Our Ref: 21/00039/HOU
Your Ref: 146 Devonshire Avenue

LOCATION: 146 Devonshire Avenue, Southsea, PO4 9EQ
PROPOSAL: Single storey rear extension (**21/00039/HOU**)

Amendments	by	Date
A		
B		
C		
Job Title 077/H/SP		
Drawing		
Proposed Plans & Elevations		
Scale: As Shown @ A1		
Drg.No: HOPA-002-P		
Drawn by: LMW		
Issued to: PCC		
Status: Planning		
Date: 09.12.20

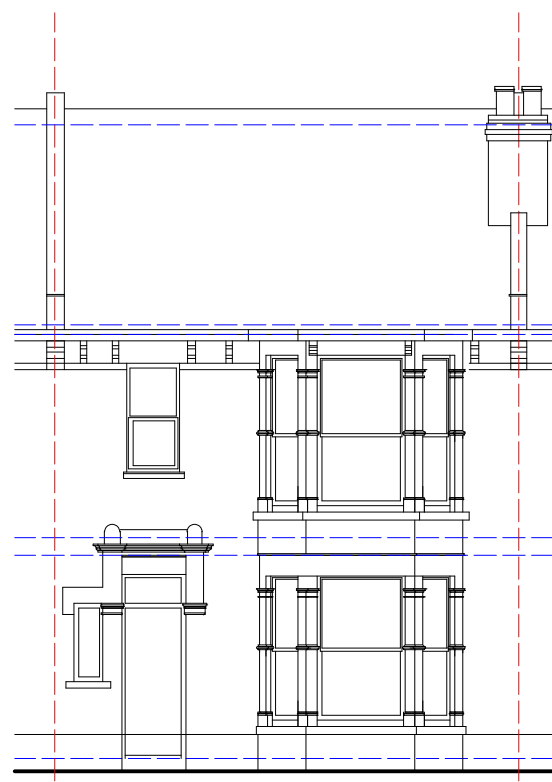
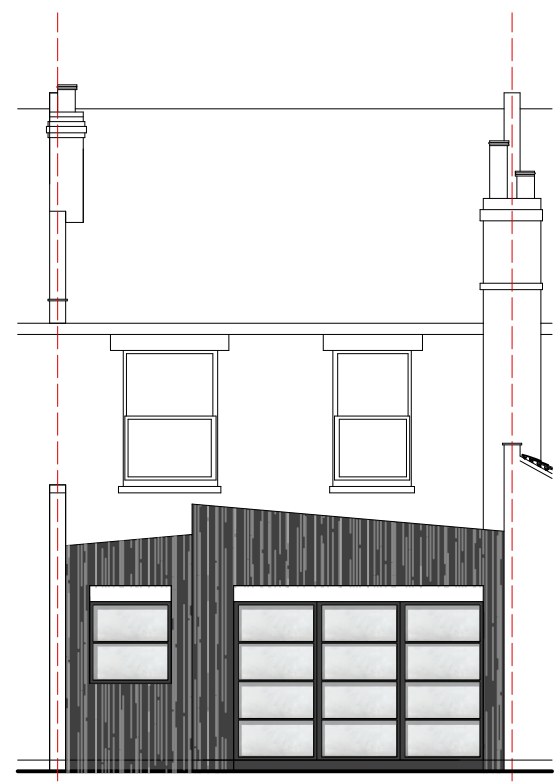
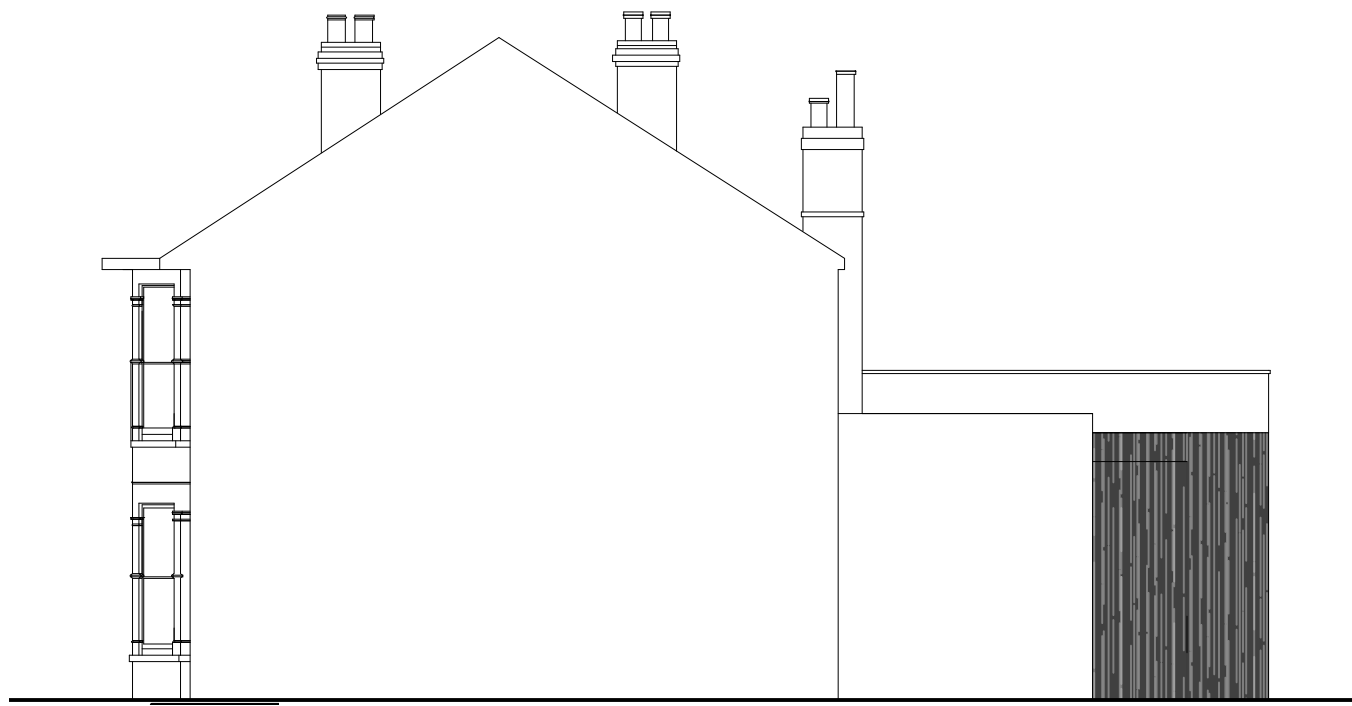
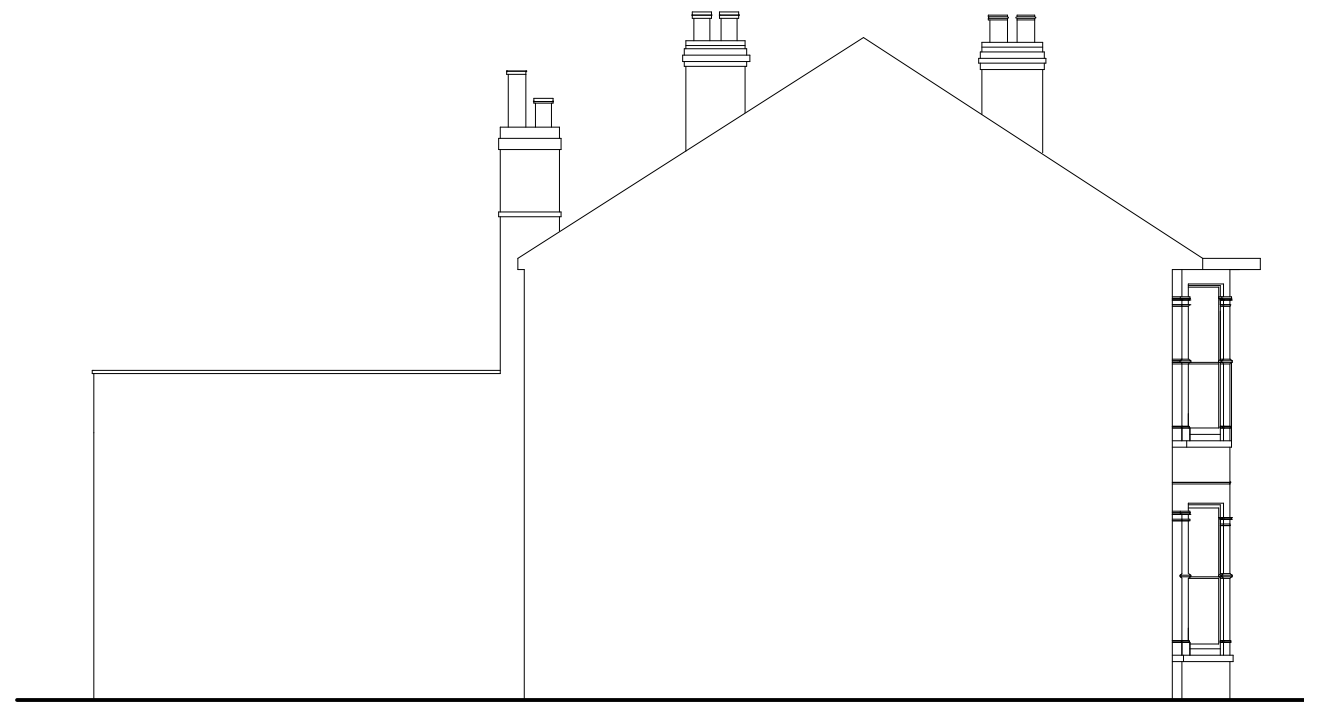
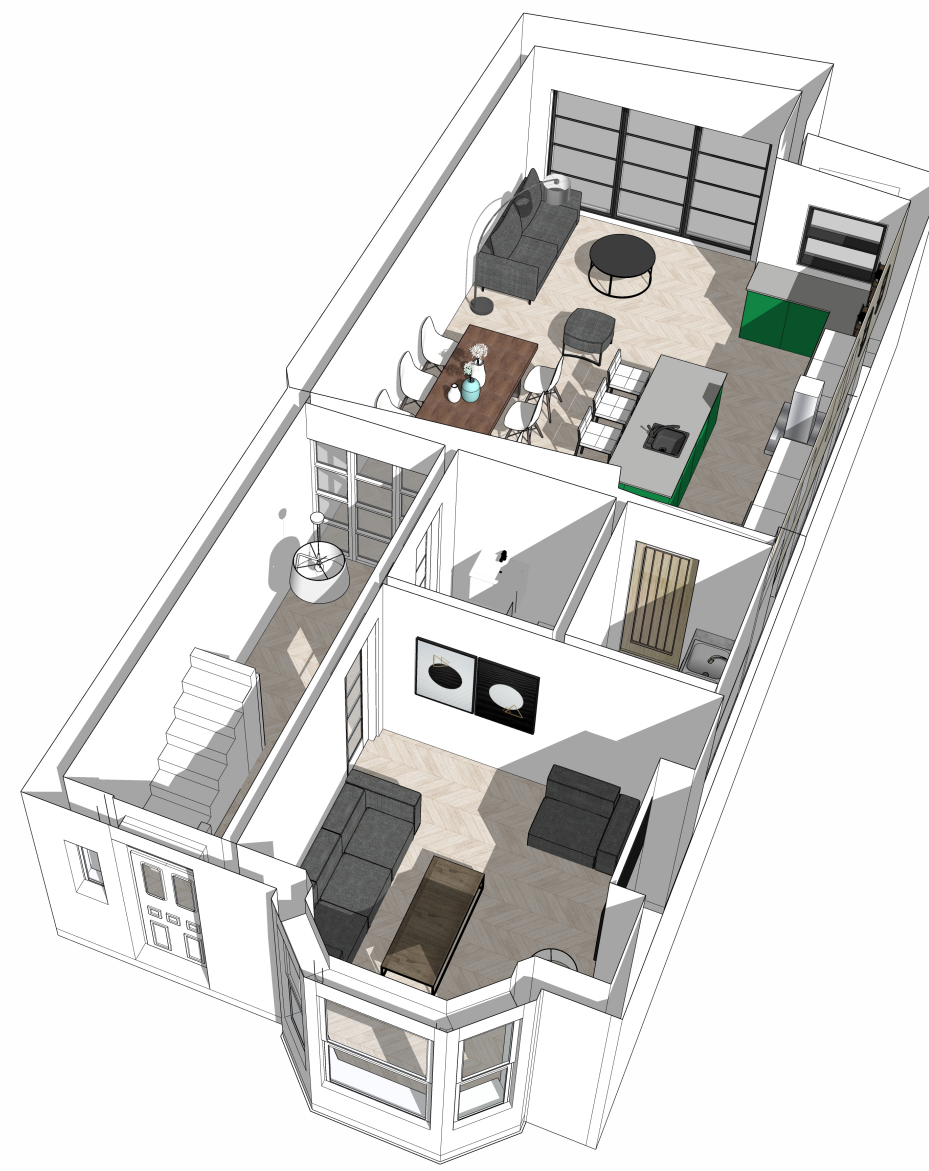
- 1) It is a requirement that all drawings are accompanied by scale bars for every size used. Please resubmit your Proposed Plans ref. HOPA-002-P with the appropriate scale bar(s) included.
- 2) Please provide a Side (East) Elevation Plan.
